The Millbrook Power (Gas Fired Power Station) Order

Explanation of Amendments Made to the Draft Development Consent Order and Other Documents – Submitted at Deadline 7

PINS Reference Number:	EN010068
Document Reference:	N/A
Regulation Number:	N/A
Author:	Pinsent Masons LLP

- Order Limits
- Unclassified roads (minor roads)
- Private roads
- Public Rights of Way (current / to remain) (Central Bedfordshire Council)
- Public Rights of Way (current / to remain) (Bedford Borough Council)

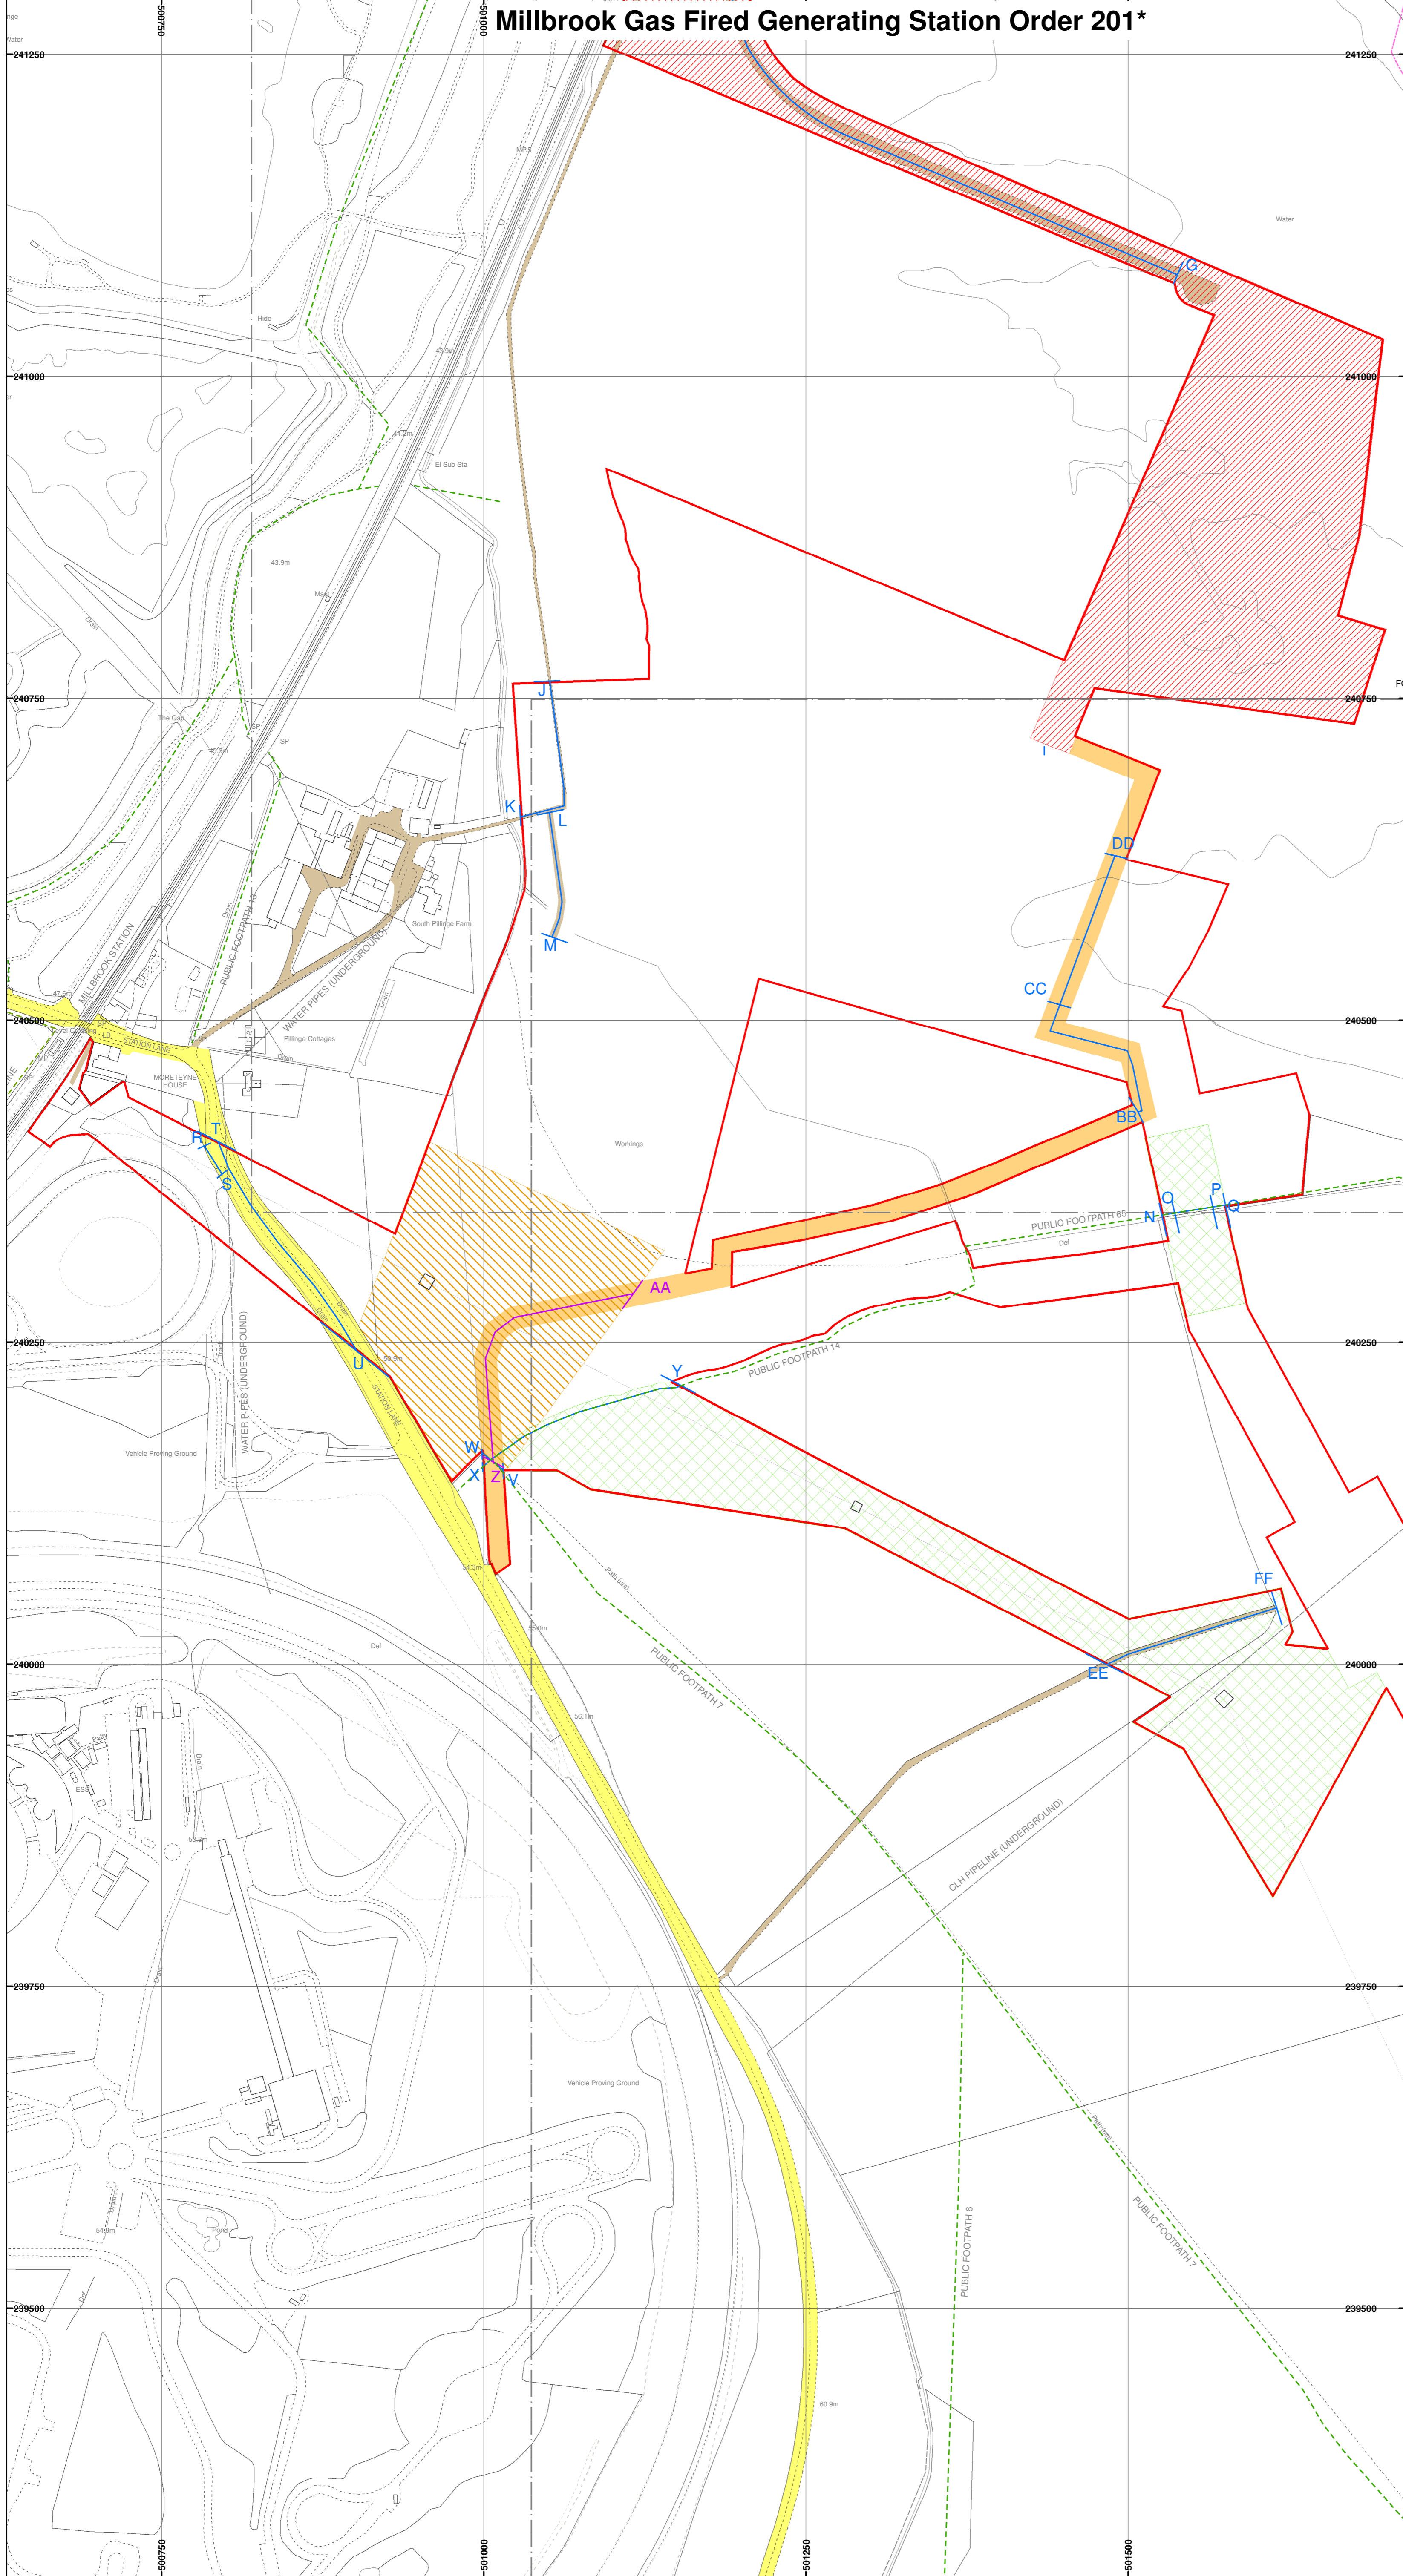
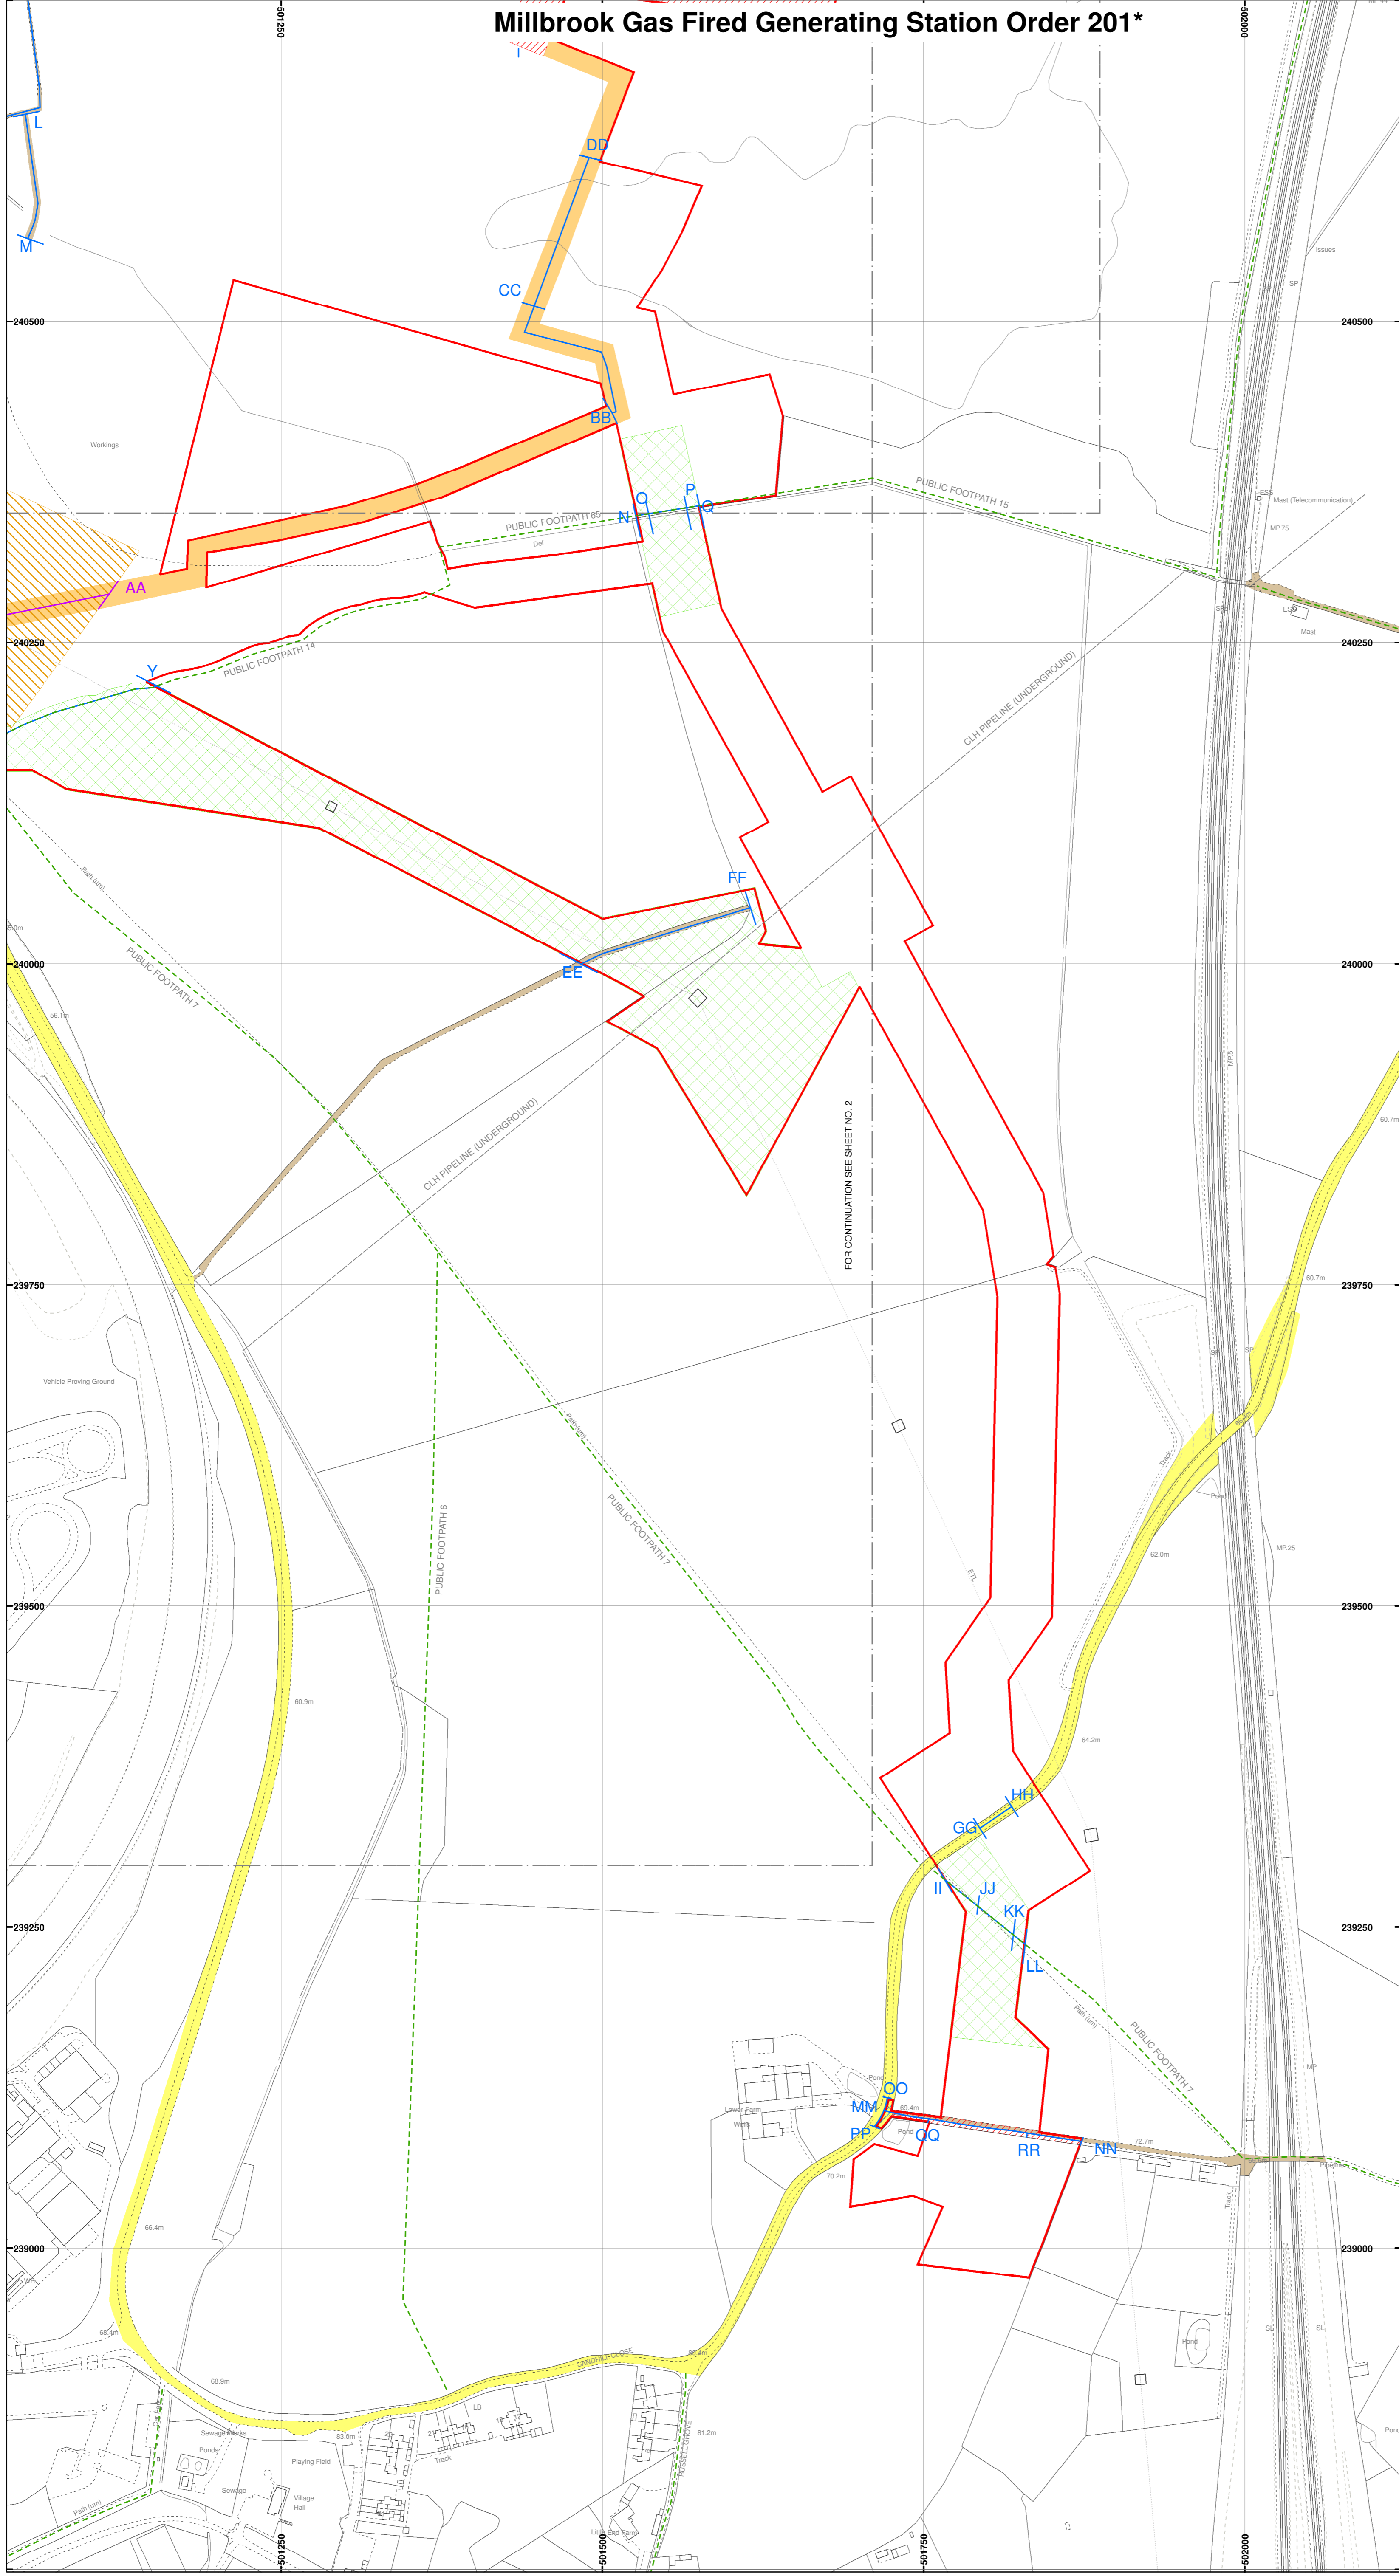
5.1 A minor change has been made to the Rights of Way Streets and Access Plan so that it now correctly refers to the "*Low Level Restoration Scheme Secondary Access Track*" instead of the "*Low Level Restoration Scheme Secondary Access Road*".
